# 1865 WOODMOOR DRIVE

### LANDSCAPE PLAN

LANDSCAPE PLAN

3  
OF 4

LANDSCAPE PLAN NOTES & DETAILS

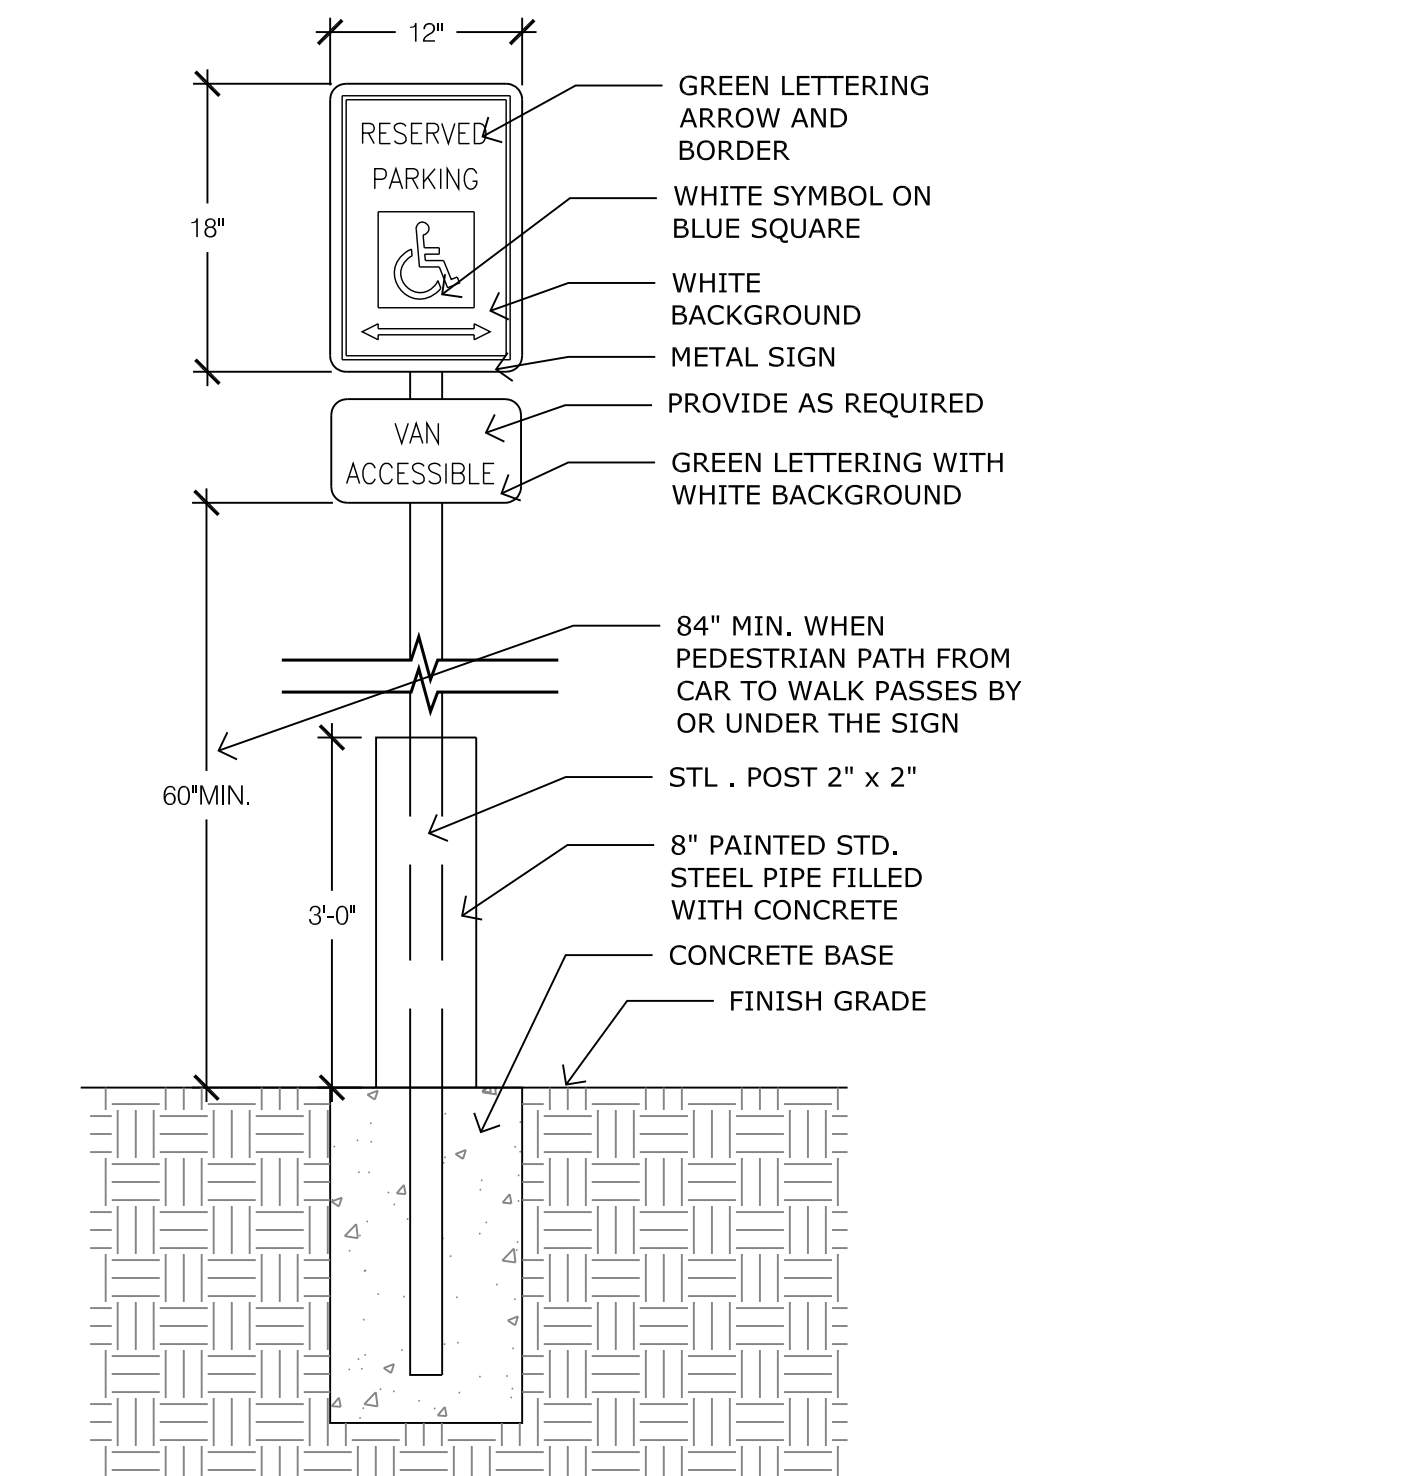
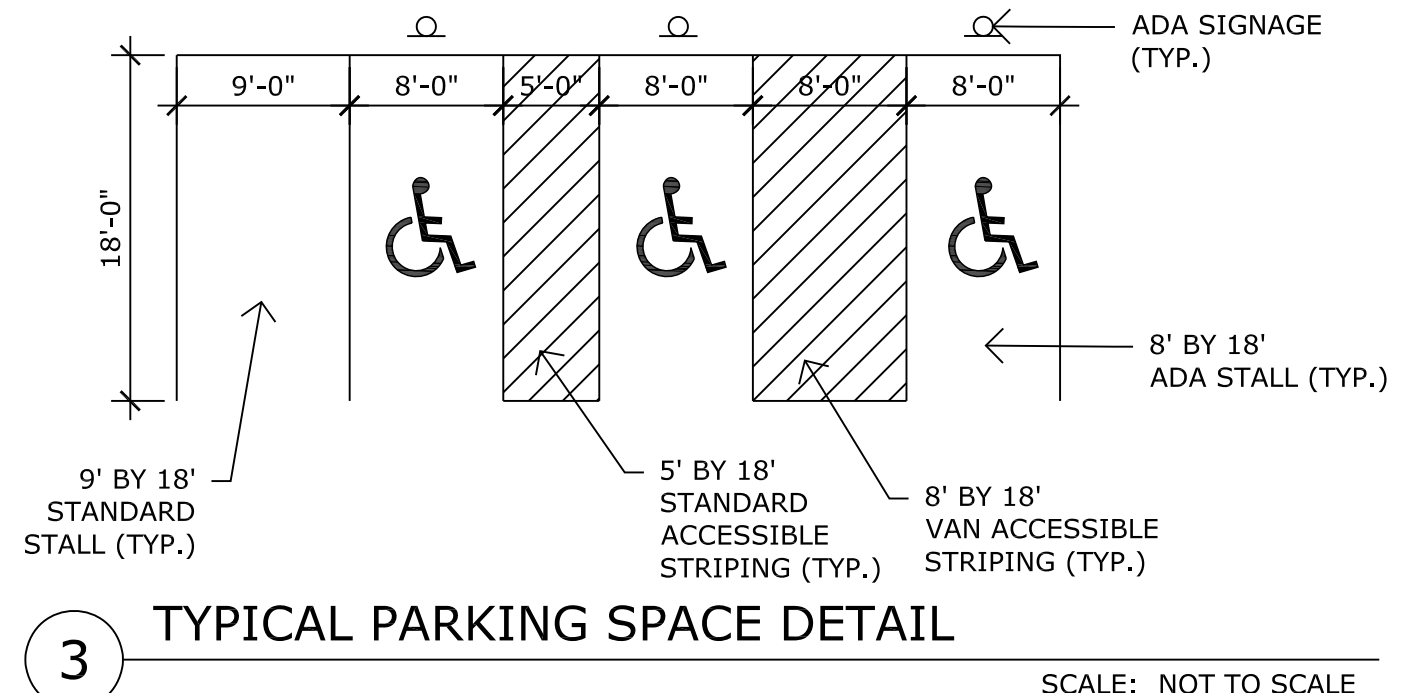
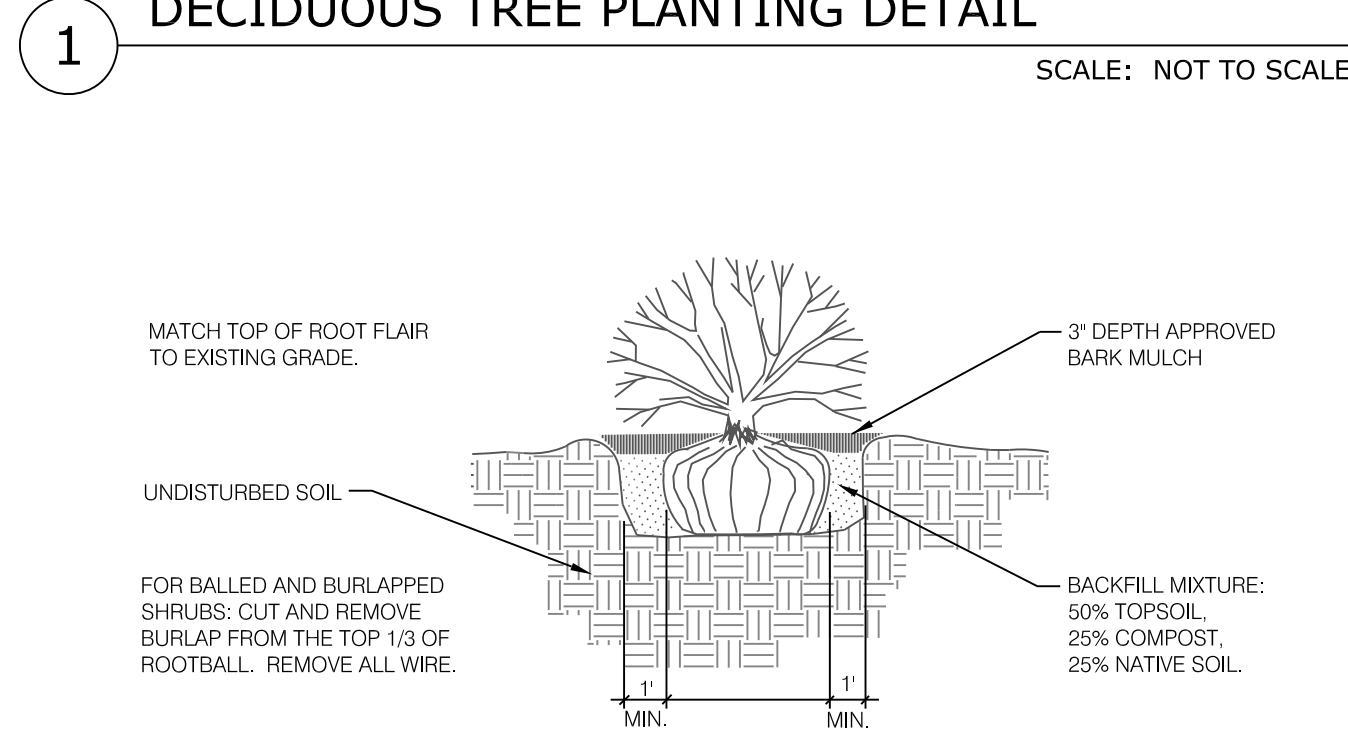
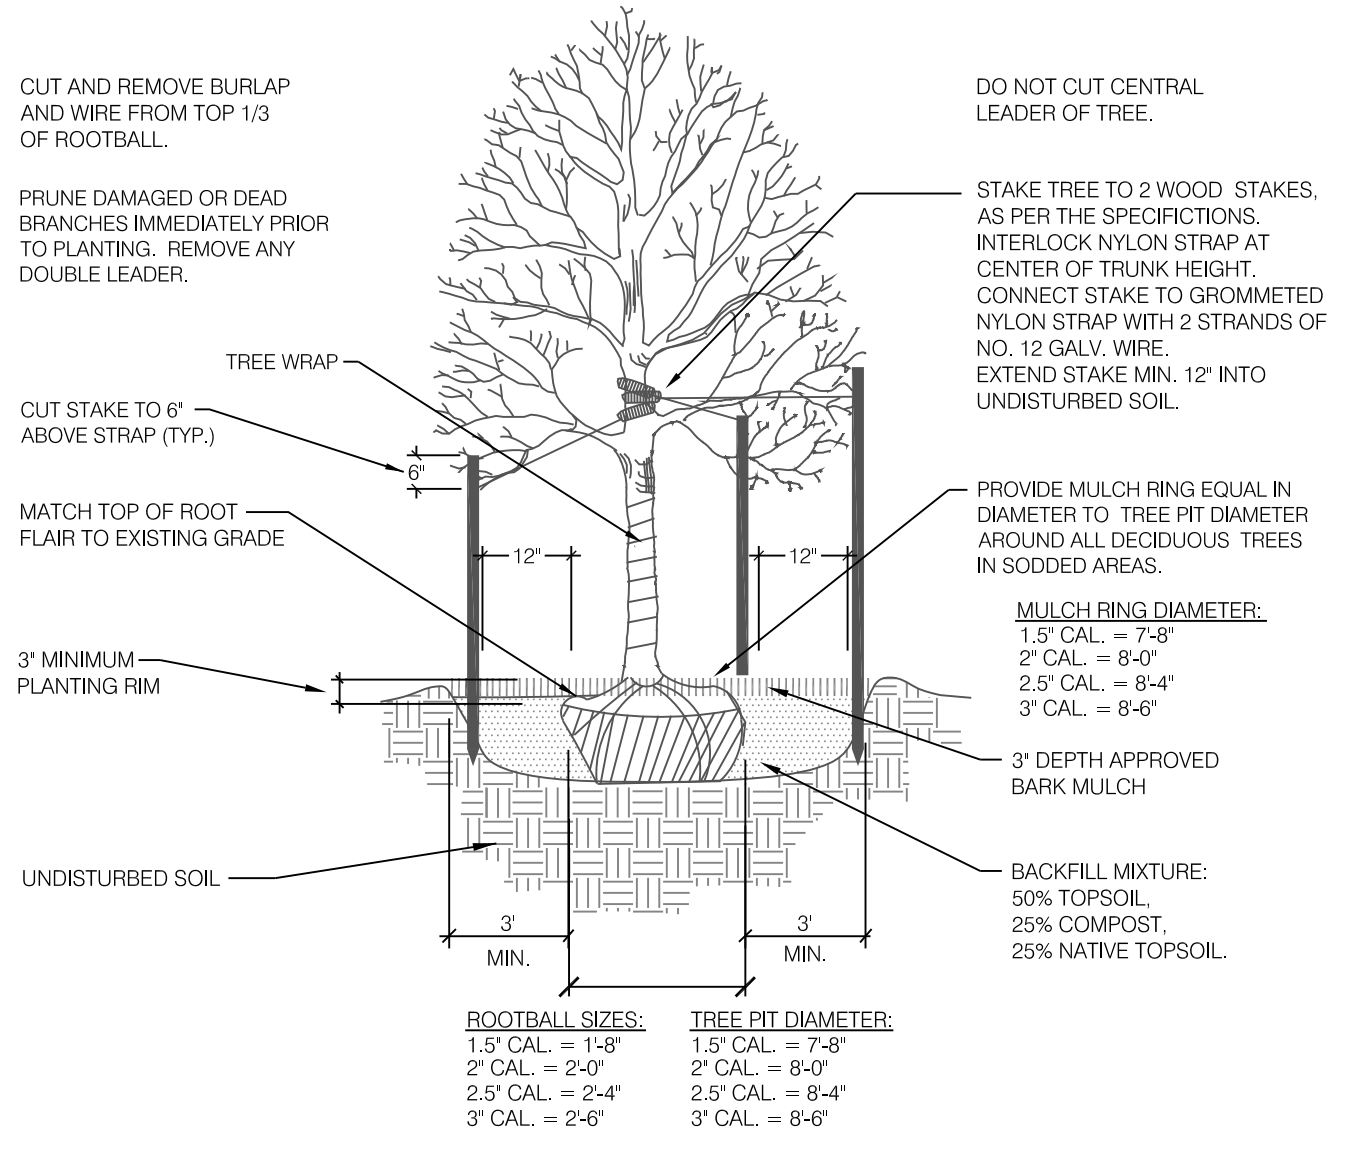
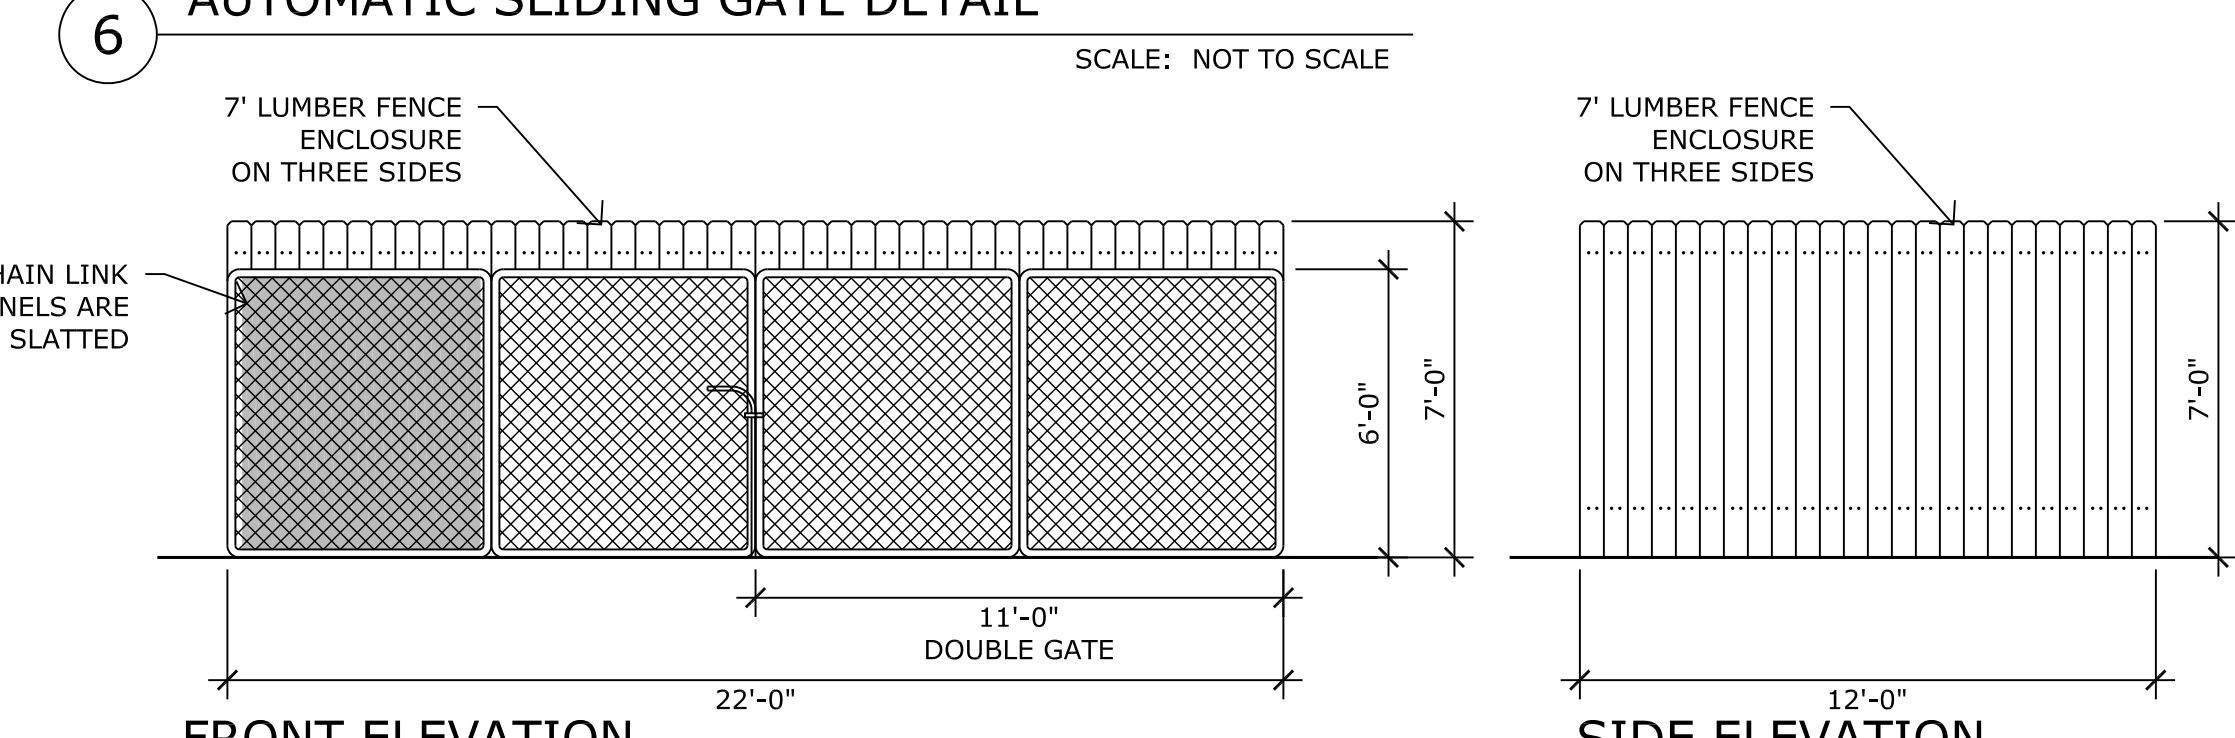
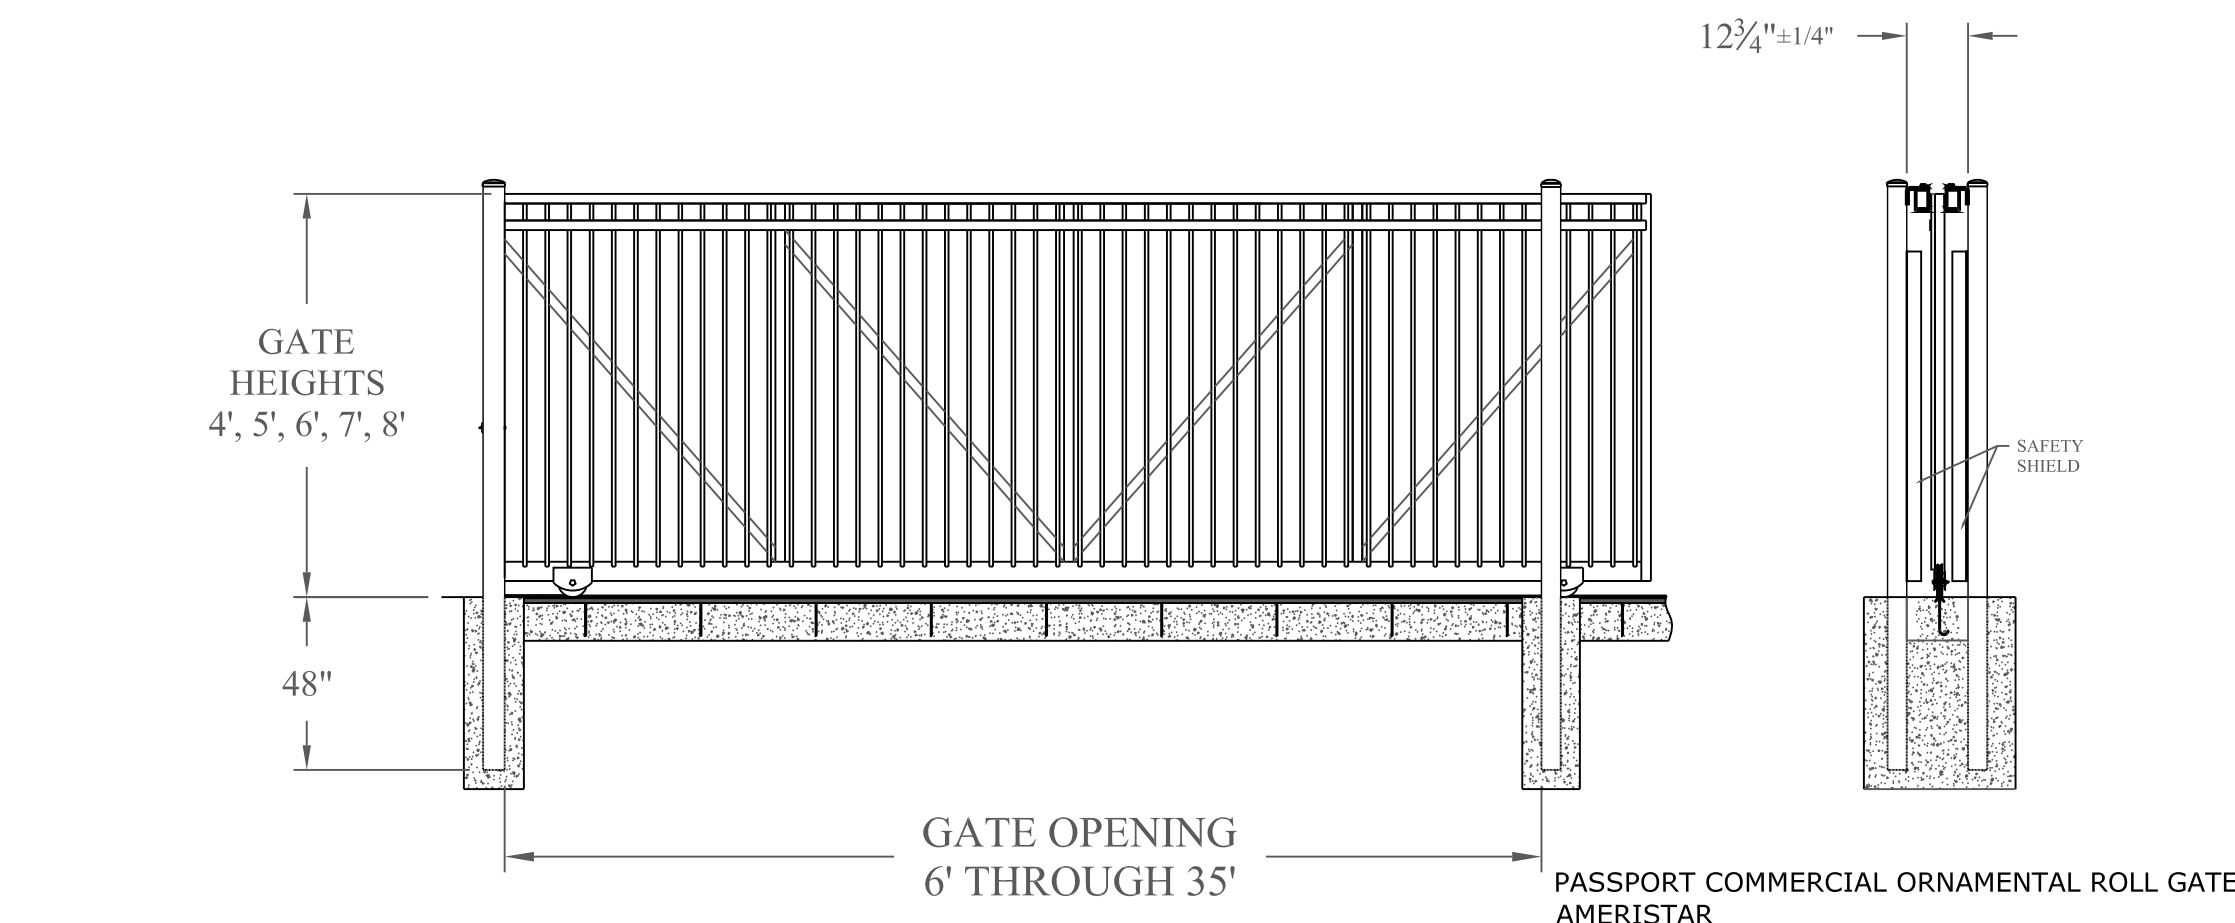
Provide fence detail(s)  
Provide trash enclosure detail.
